**TOWER 2, LEVEL 23
DARLING PARK, 201 SUSSEX ST
SYDNEY NSW 2000**

MP 08_0241 MOD 5 - RESPONSE TO SUBMISSIONS

We write in response to submissions received in regards to the MOD 5 application for Major Project 08_0241 at 100 Mount Street, North Sydney. We've reviewed the submissions received and provide responses for each below.

Plan - B5 Level

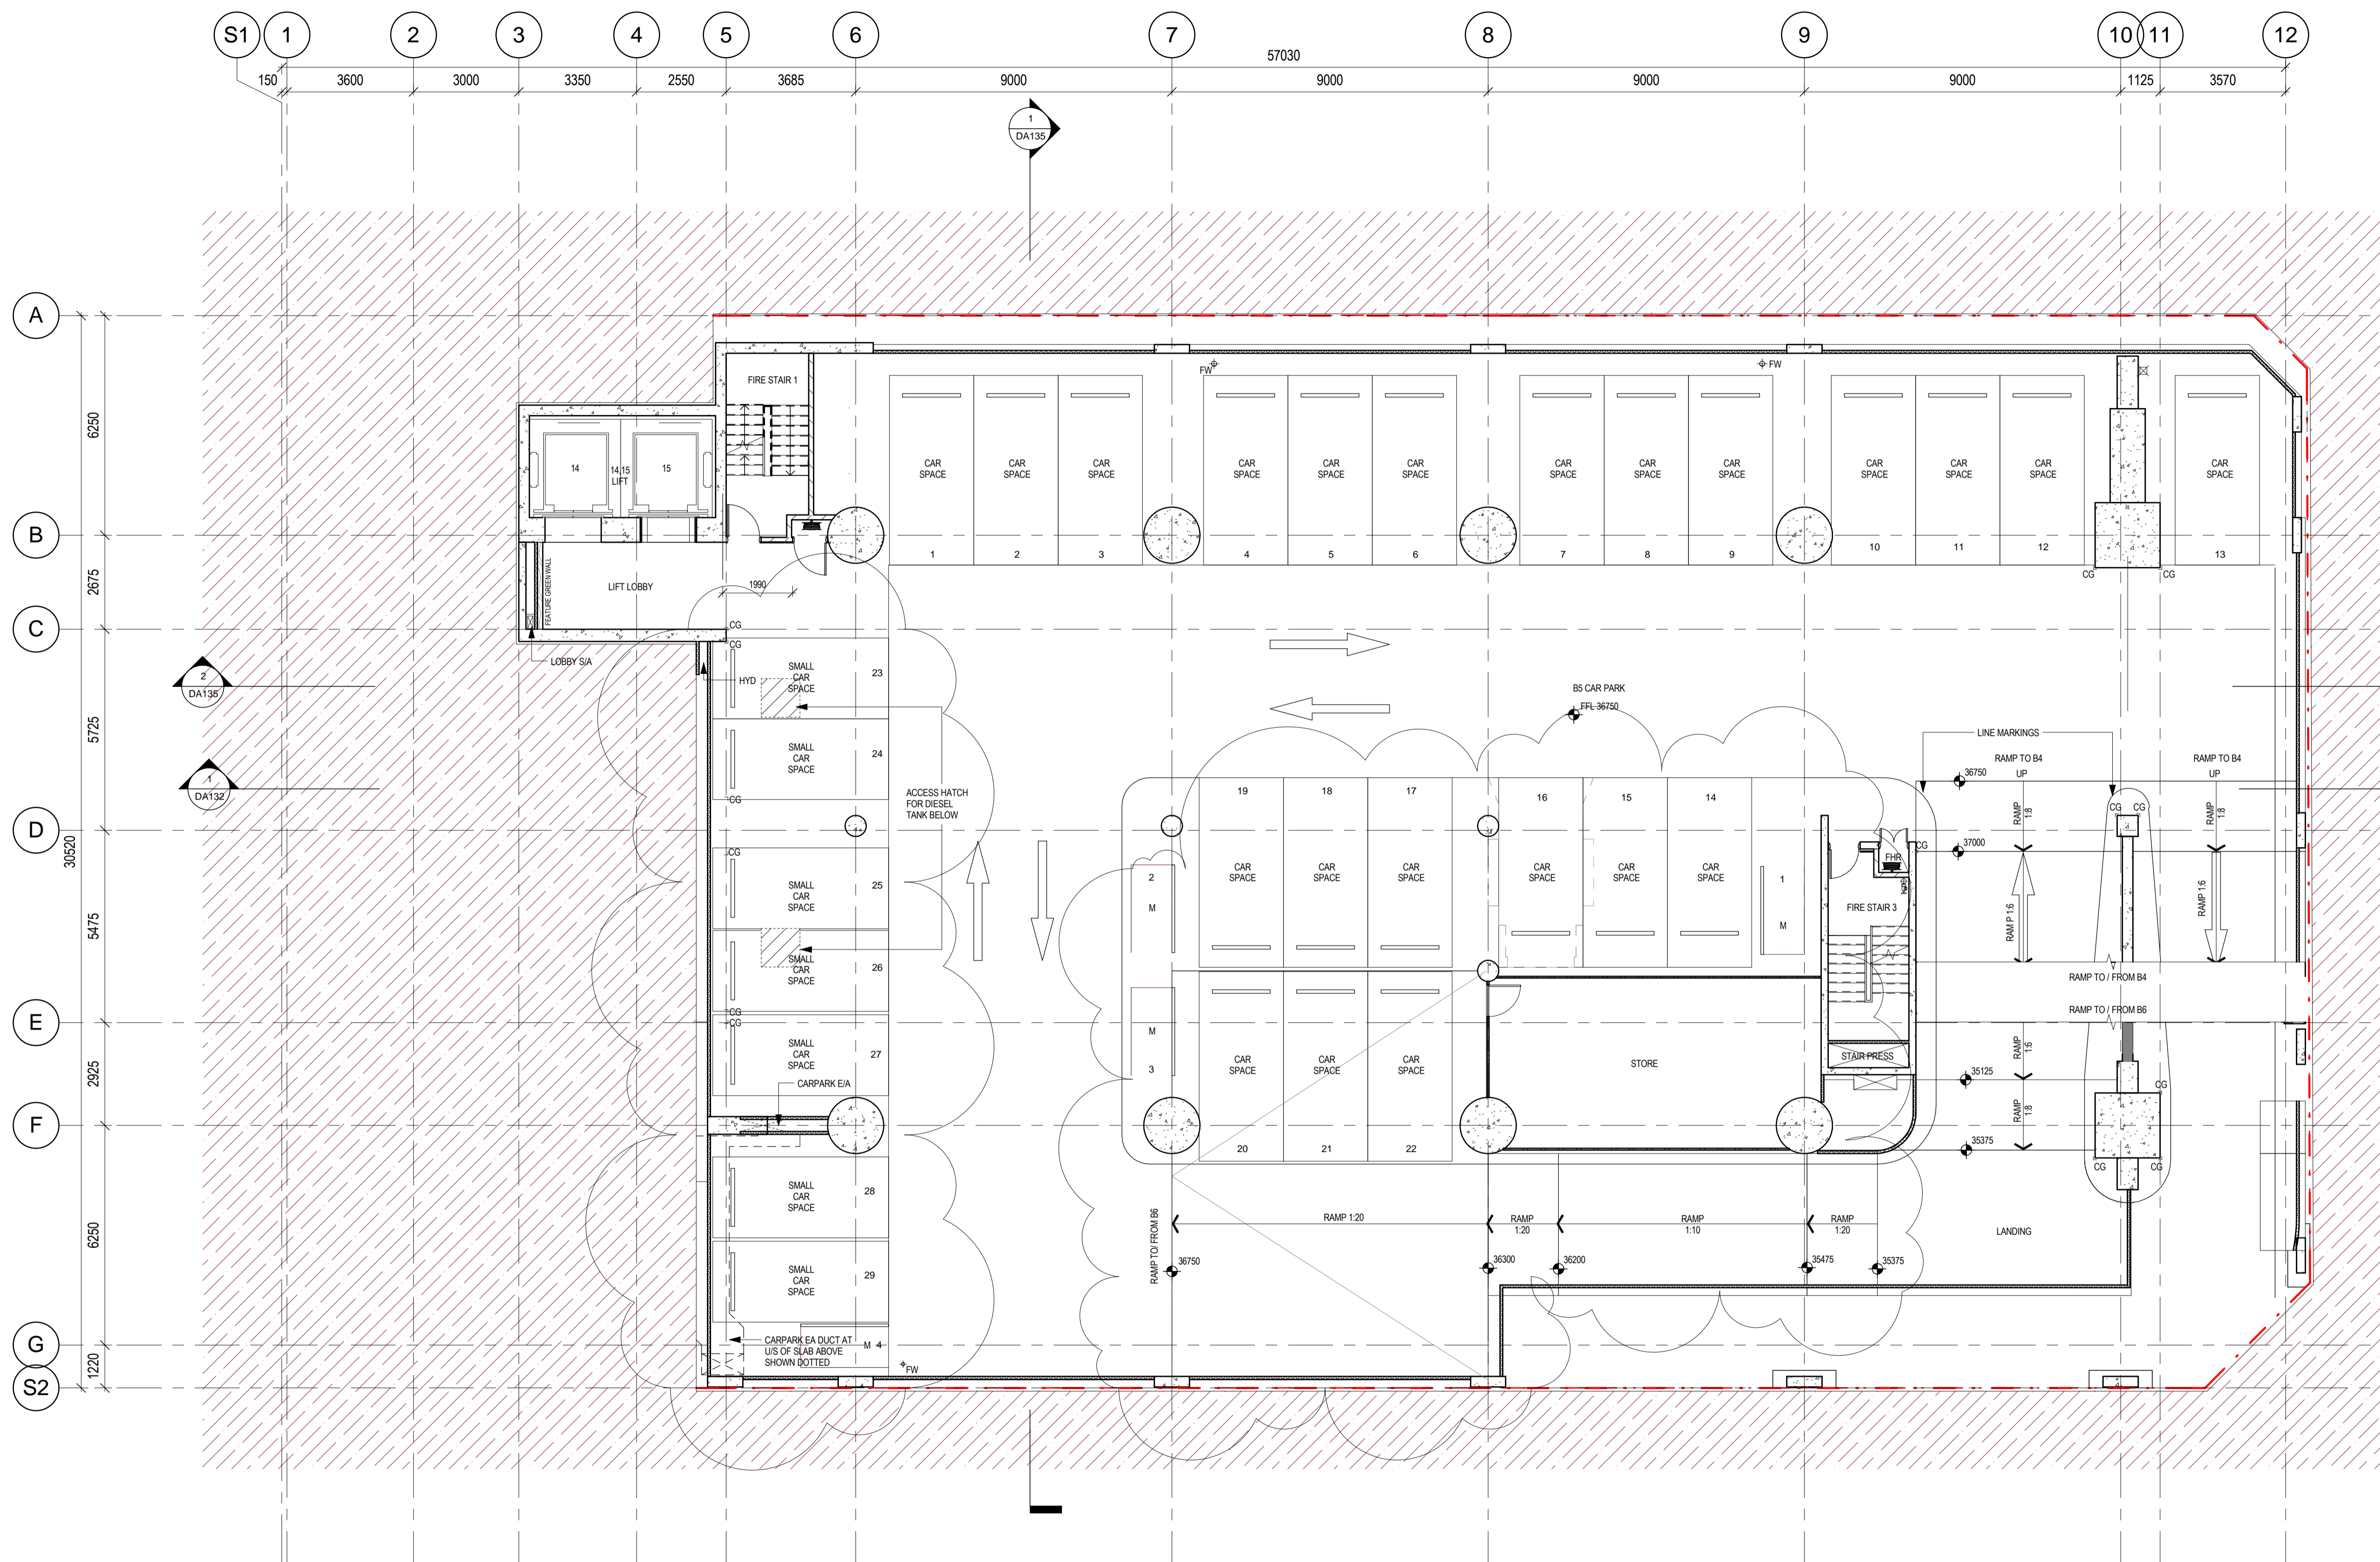
Council has raised an issue with the proposed decrease in bicycle parking from 330 spaces to 234 spaces. While we note that the proposal does not comply with the North Sydney Development Control Plan 2013, the reduction in bicycle parking is related to the change in the Green Star rating system (Office v3 to Design & As-Built v1.1) which reduced the requirement of providing cyclist facilities from 10% to 7.5% of workers.

Should the demand for bicycle parking warrant increased facilities in the future, there are a number of storage areas on Basement Level 5 and 6 which can be converted. However, it is not considered necessary to provide additional facilities at this point in time.

Based on the above, we submit that the 234 bicycle parking spaces provided in the proposal are sufficient.
